**EL PASO COUNTY PLANNING AND  
 COMMUNITY DEVELOPMENT  
 DEPARTMENT**

**GRADING AND EROSION CONTROL PLAN CHECKLIST**

Revised: July 2019

**LORSON RANCH
CREEKSIDE DEVELOPMENT
EAST FORK JIMMY CAMP CREEK
GRADING AND EROSION CONTROL PLAN
EL PASO COUNTY, COLORADO**

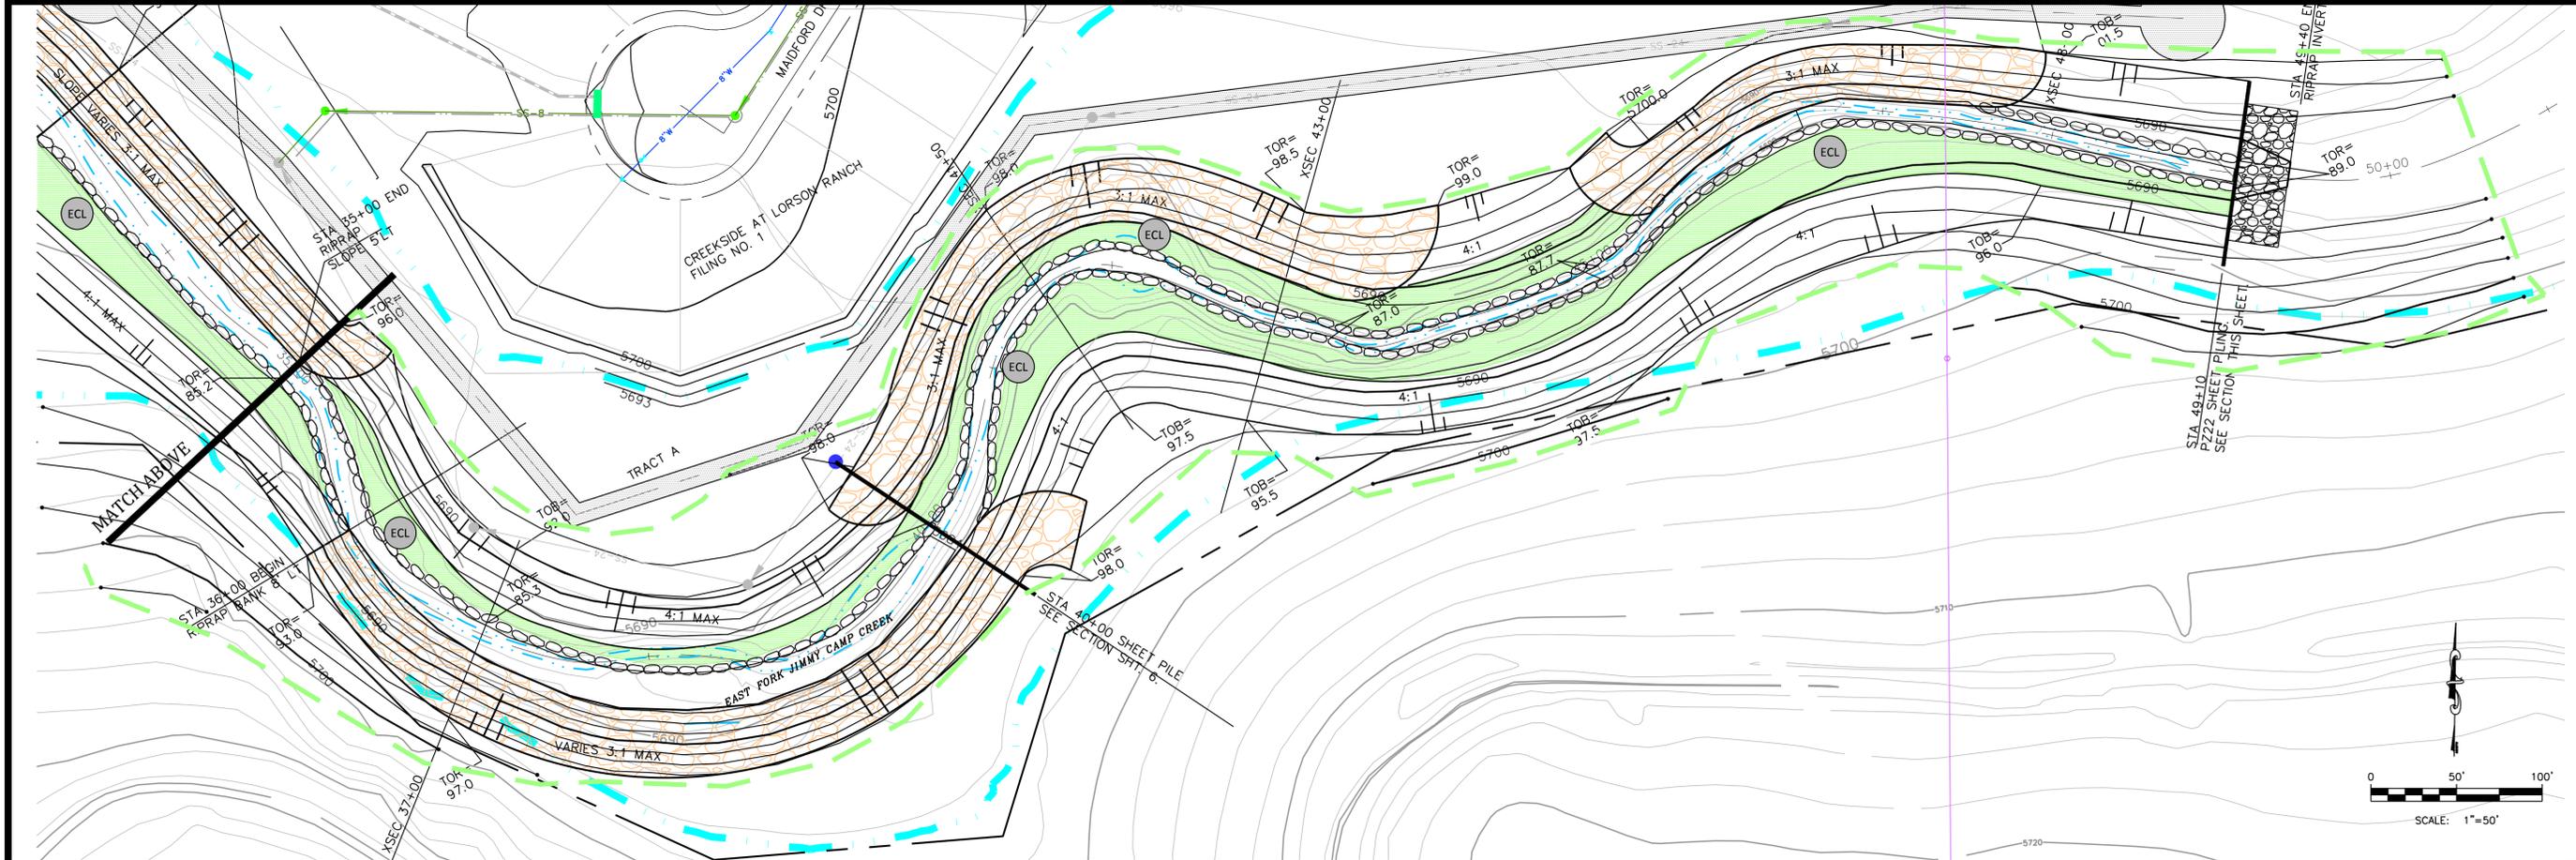
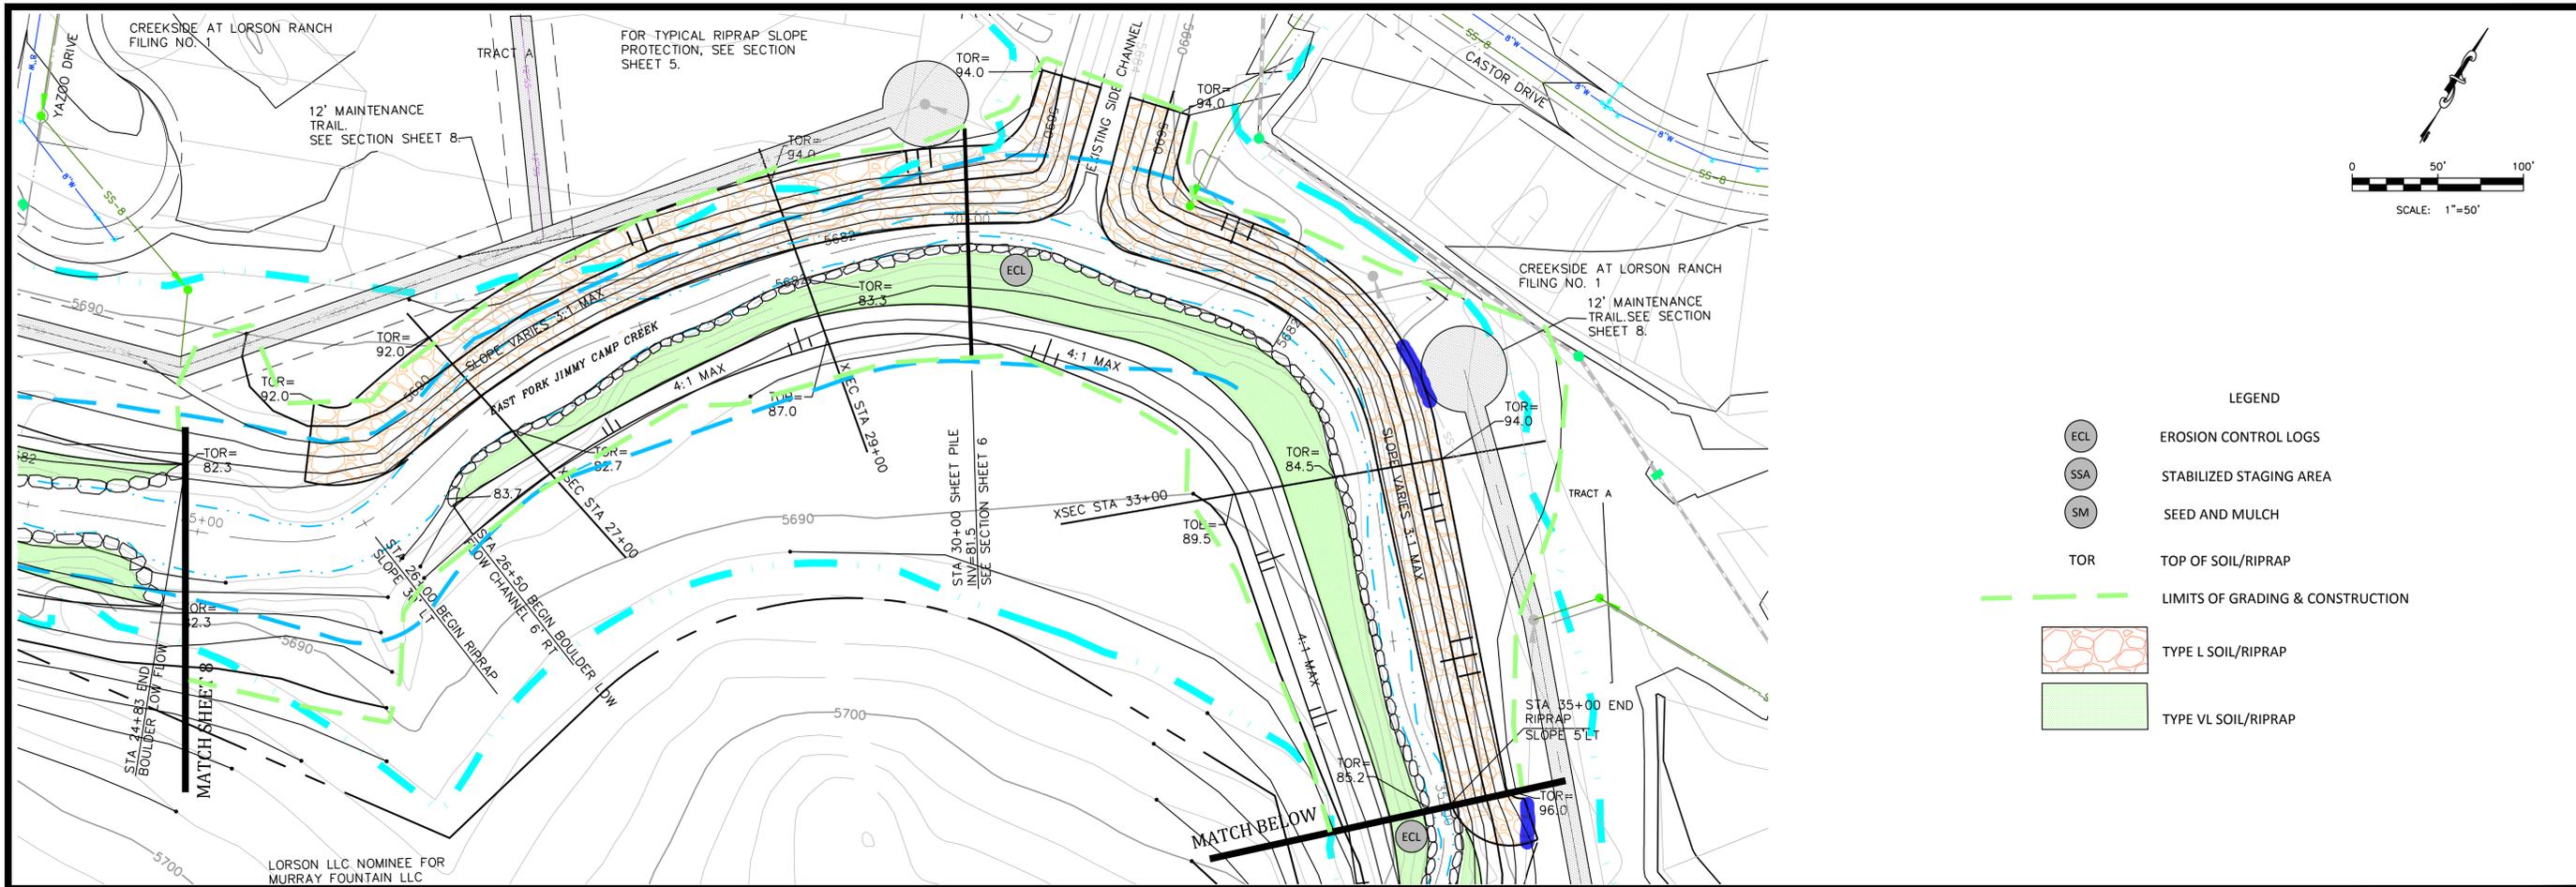
CWA, VTC, larger plan?
